December 3, 2013

Nell Donaldson
City of Portland, Division of Planning
389 Congress Street
Portland, Maine 04101

We are writing in response to comments forwarded us by the project landscape architect, Pat Carroll.

**Typical Window & Door Head Elevation Detail
N.T.S.**

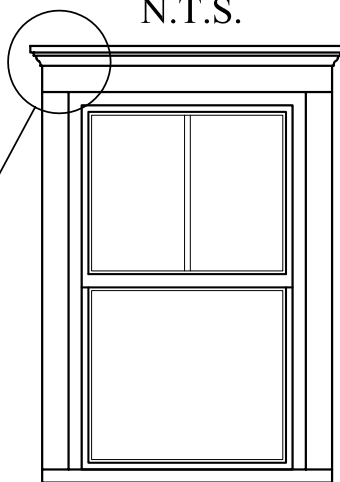
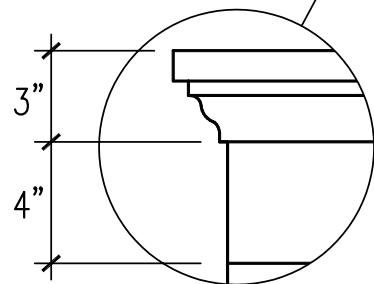
The revised window head lintels are detailed on the drawings. A lintel trim profile has been included in the project.
